CITY OF PORTLAND BUILDING PERMIT

Job ID: 2011-04-824-ALTCOMM

has permission to Do interior renovations including new men's bathroom, partitions and finishes provided that the person or persons, firm or corporation accepting this permit shall comply with all of the provisions of the Statues of Maine and of the Ordinances of the City of Portland regulating the construction, maintenance and use of the buildings and structures, and of the application on file in the department.

**CONSIGLI OFFICE RENOVATION
15 FRANKLIN ST, PORTLAND**

NEW MEN'S HC BATHROOM

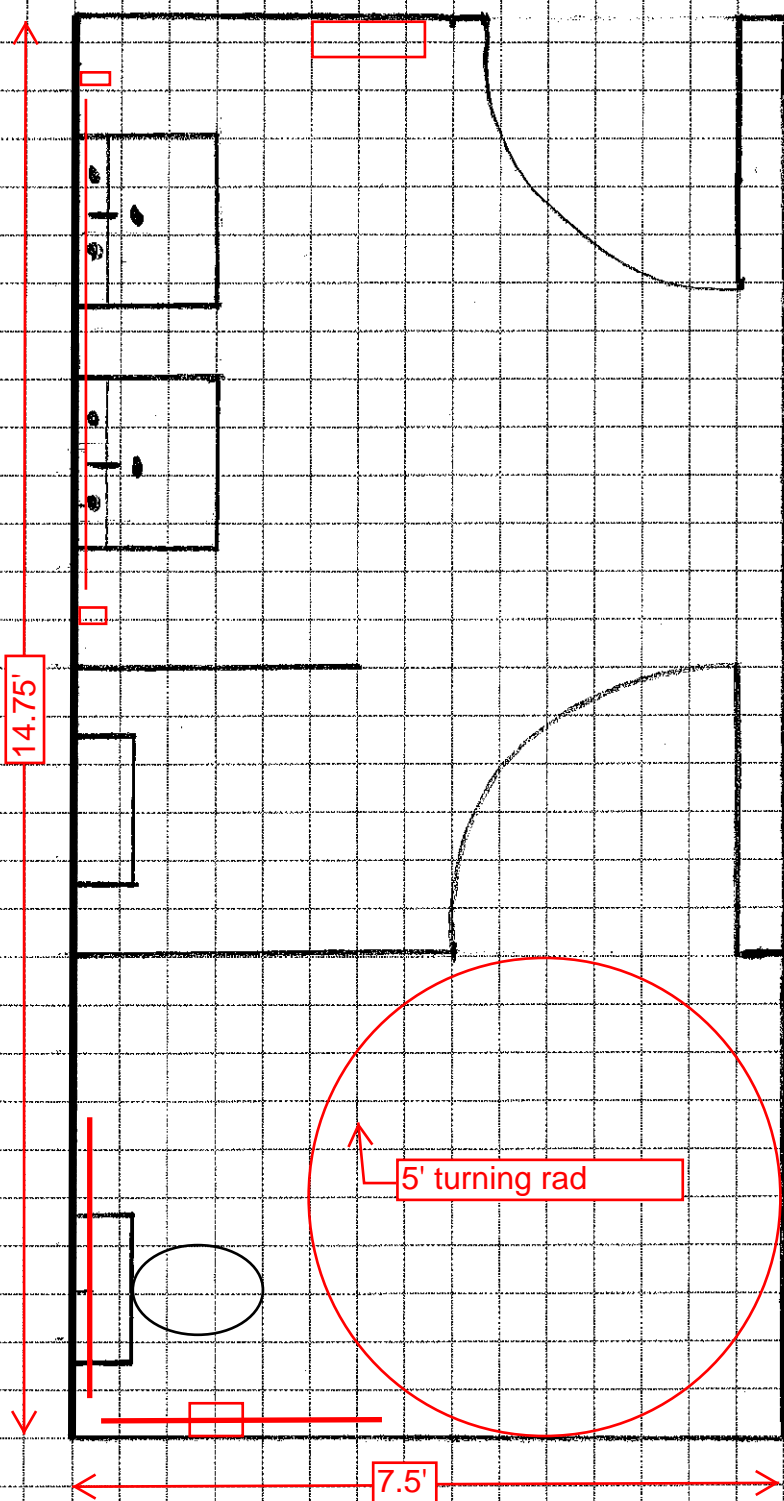
1. Application approval based upon information provided by applicant. Any deviation from approved plans requires separate review and approval prior to work.
2. All penetrations through rated assemblies must be protected by an approved firestop system installed in accordance with ASTM 814 or UL 1479, per IBC 2009 Section 713.
3. Separate permits are required for any electrical, plumbing, sprinkler, fire alarm, HVAC systems, heating appliances, including pellet/wood stoves, commercial hood exhaust systems and fuel tanks. Separate plans may need to be submitted for approval as a part of this process.
4. As agreed with Chris B., a floor drain is required in the new men's bathroom

**EXISTING FIRE SUPPRESSION PLAN**

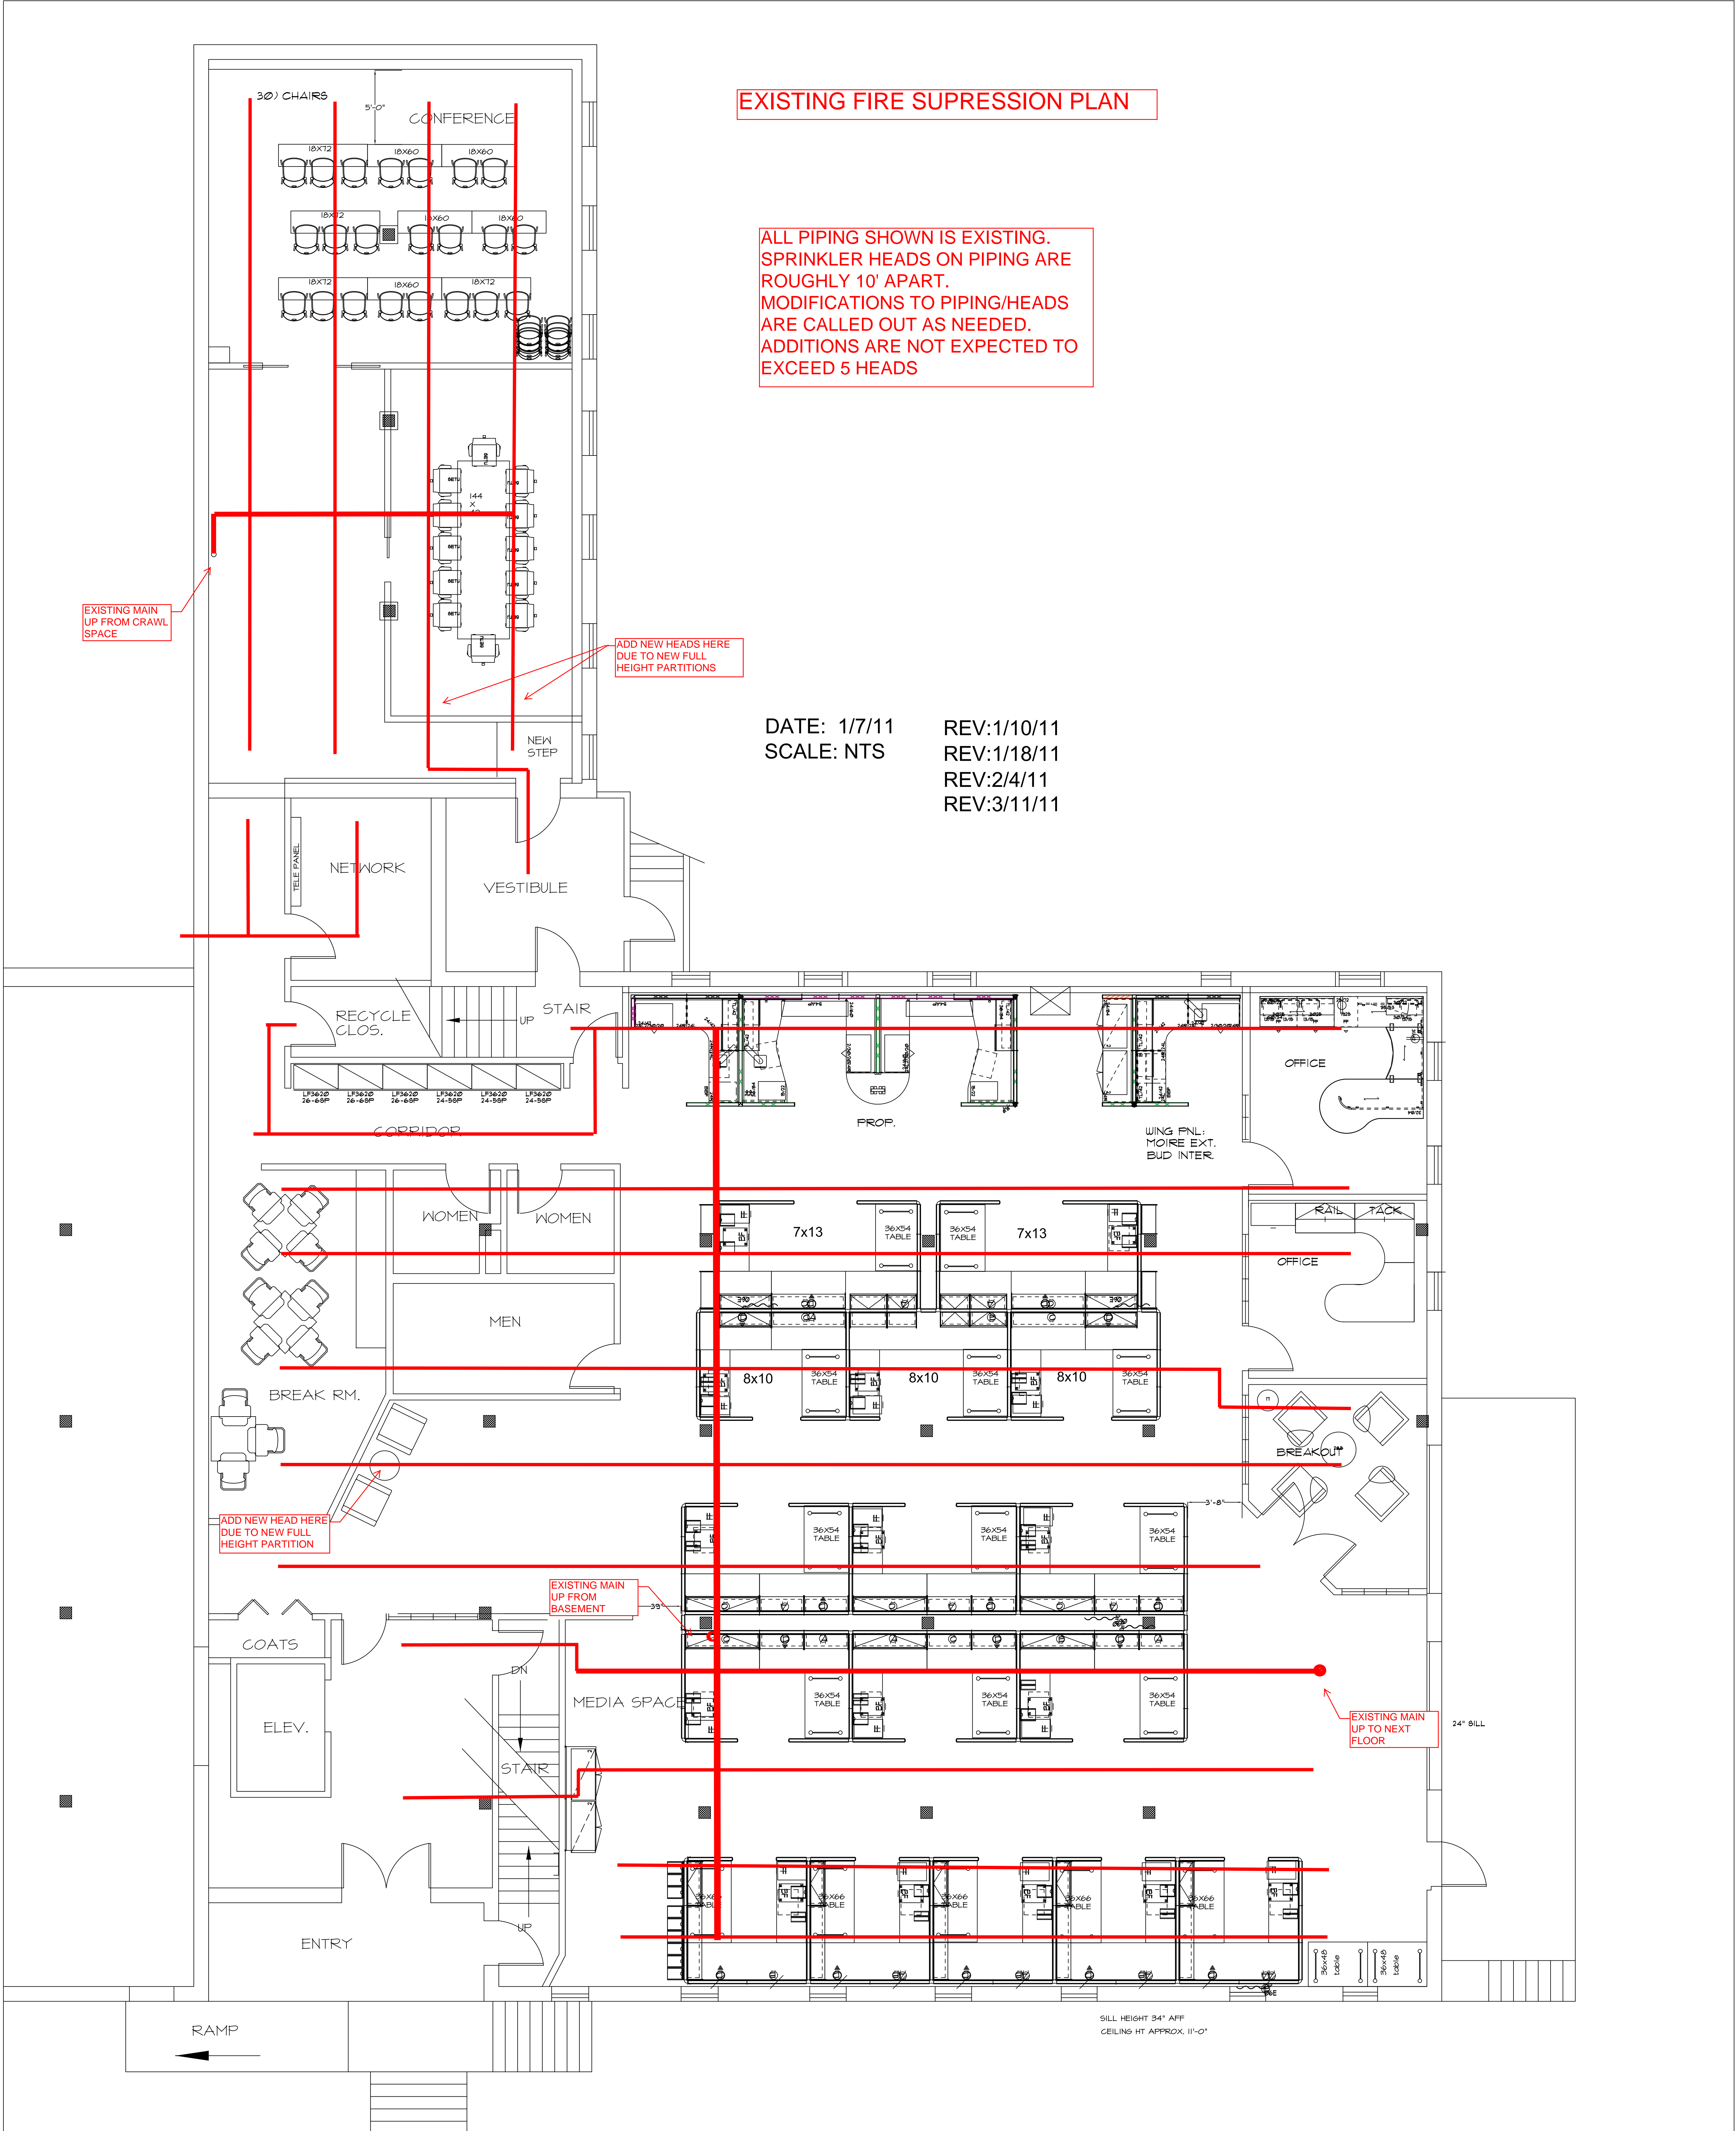
3. The Fire alarm and Sprinkler systems shall be reviewed by a licensed contractor[s] for code compliance. Compliance letters are required.
4. A separate Fire Alarm Permit is required for new systems; or for work effecting more than 5 fire alarm devices; or replacement of a fire alarm panel with a different model.

5. A separate Suppression System Permit is required for all new suppression systems or sprinkler work effecting more than 20 heads.
6. Installation of a sprinkler or fire alarm system requires a Knox Box to be installed per city ordinance.
